The Planning Inspectorate

Reference: OR-0012690/01

**ENVIRONMENT AGENCY RESPONSE TO EXAMINING AUTHORITY'S WRITTEN
QUESTIONS 1 (EXQ1). LIGHT VALLEY SOLAR.**

Drawing Title
Figure 6.12
Fish Habitat Assessment, EA Monitoring Locations and eDNA Survey Locations
Sheet Number 1 of 7

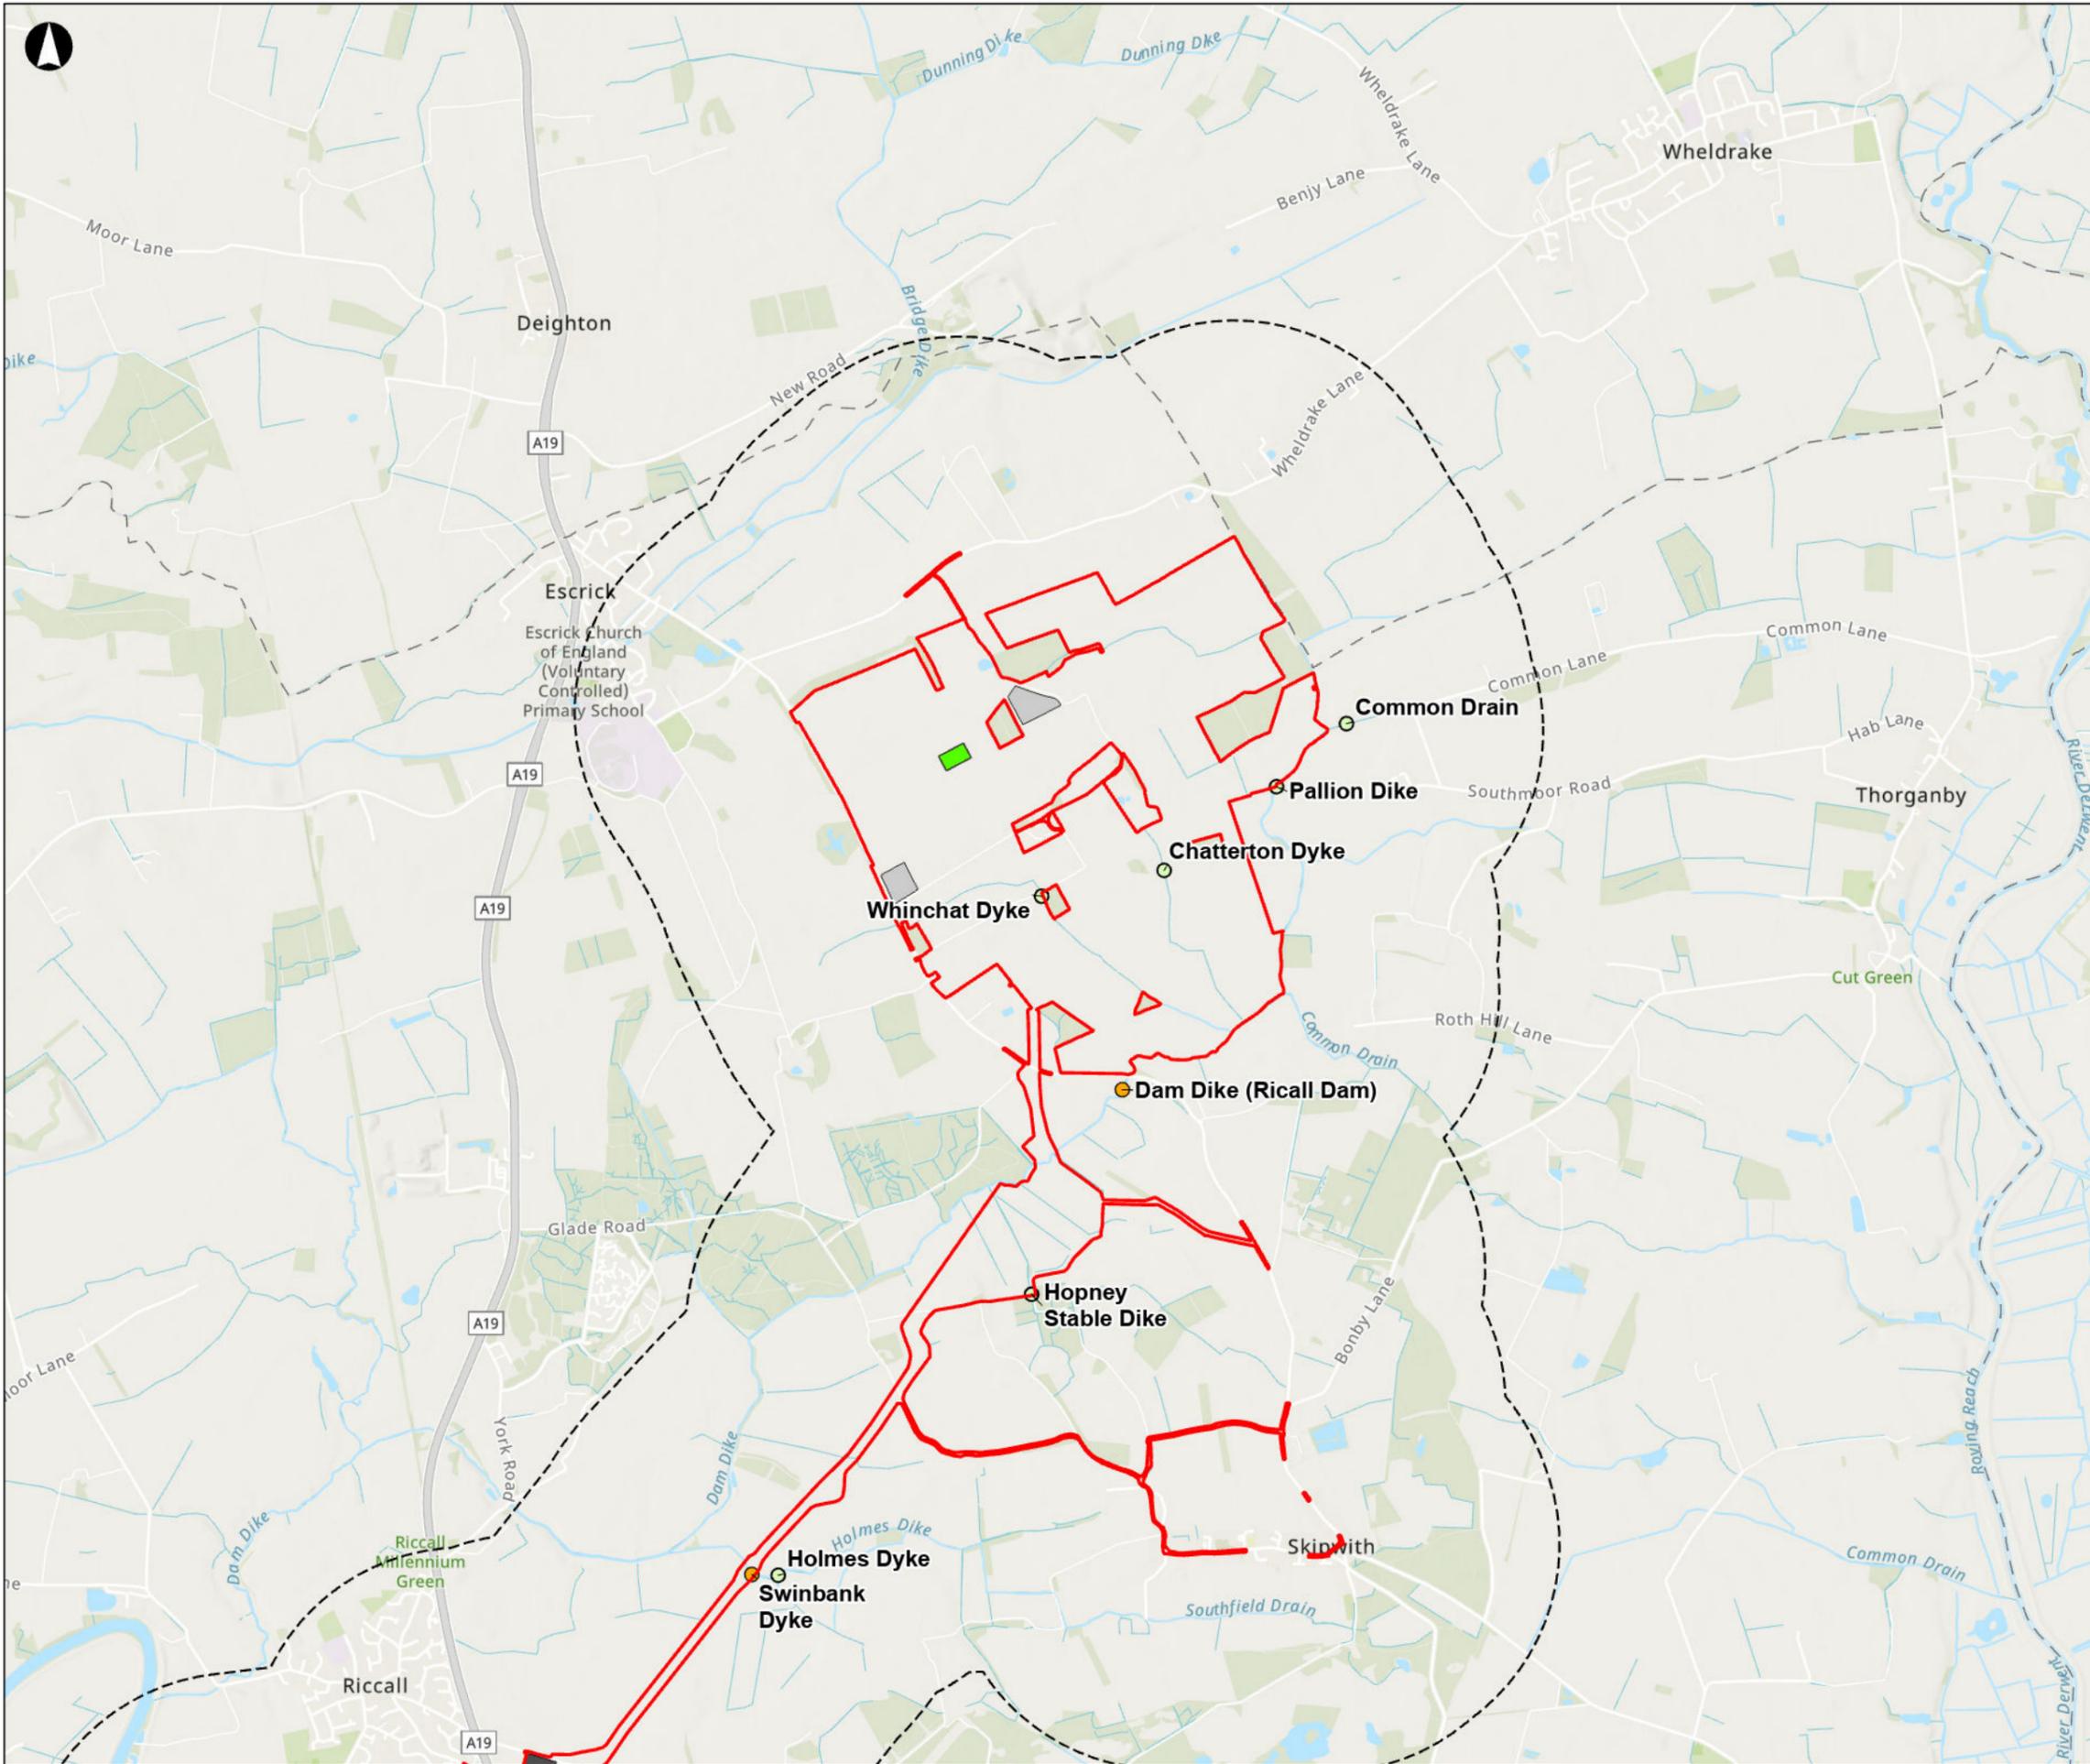
We are satisfied with the Applicant's response to this issue. No updates are required to the recently submitted draft documents as part of this consultation, as the relevant detail is already captured within the Examination Library, namely Figure 6.12 Fish Habitat Assessment, EA Monitoring Locations and eDNA Survey Locations [APP-083]. The Applicant has provided clarification that reassures us on the design approach and baseline survey methodology. We are satisfied that the eDNA surveys were appropriately targeted at watercourses and waterbodies where suitable fish habitat exists and where potential impact pathways to fish receptors are present, which represents a sensible and proportionate approach to the baseline assessment.

The Applicant has also confirmed that no impact pathways to fish receptors exist within Hagg Lane Drain and Mearley Drain, given the retention of a 10 m buffer and the use of an existing crossing. We are therefore satisfied with the Applicant's response, and this issue is considered resolved.
